C19/D049

Michael Smith, P.E.
5003 Dream Dancer Dr NE
Rio Rancho, NM 87144
505-771-8677

Re: New Covenant Church Grading Plan Comments for Site Development Plan and Preliminary/ Final Plat
Site: 7200 Holly NE (C19/D49)

GRADING PLAN REVISION

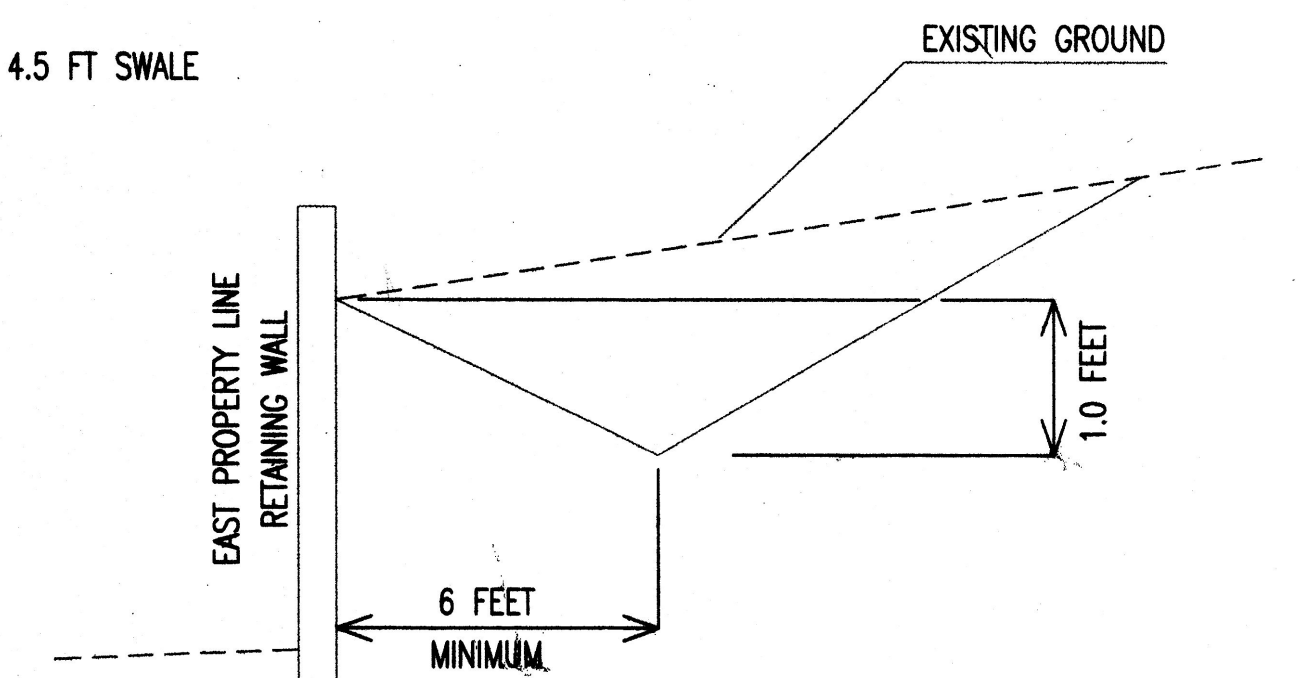
- 1) The capacity of the inlets in Holly are 7 cfs each. The capacity of the 30" storm drain is 119 cfs.
- 2) The storm drain from the pond east has only been constructed to accommodate the central reach of Holly Avenue. The storm drain has not been constructed to the existing local low point east of our site. Our site does not contribute flow to this low point.
- 3) Holly Street Capacity = 171 cfs
- 4) The total developed runoff contributing to the AMAFCA pond per the North Albuquerque Acres Master Drainage Plan assumptions will be 119 cfs.
